**Application for Planning Permission for Works or Extension to a Dwelling**

**Development:** Extension at rear of property, loft conversion and various changes to fenestration.  
**Location:** 59 Tarrant Street Arundel BN18 9DJ

SIDE ELEVATION - EXISTING

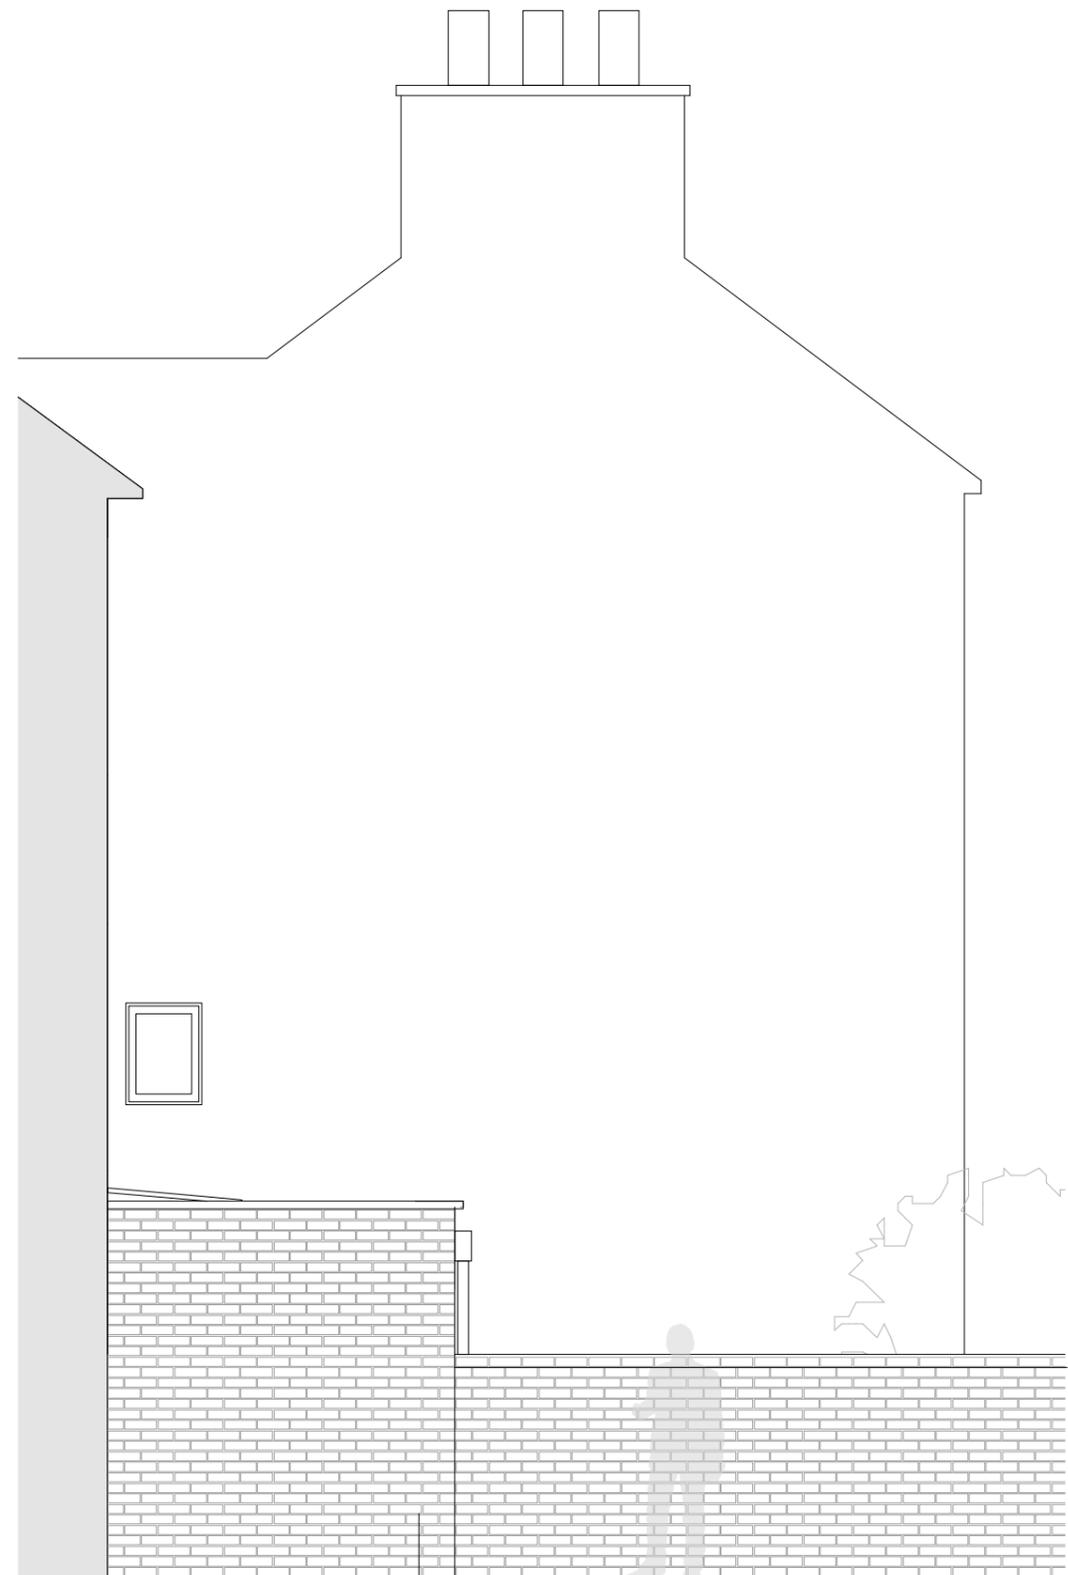
Please submit electronic plans in pdf format clearly labelled existing and proposed side elevations (from 61 Tarrant Street) at a scale of 1:50 or 1:100. Further details can be found in the Validation Requirements List.
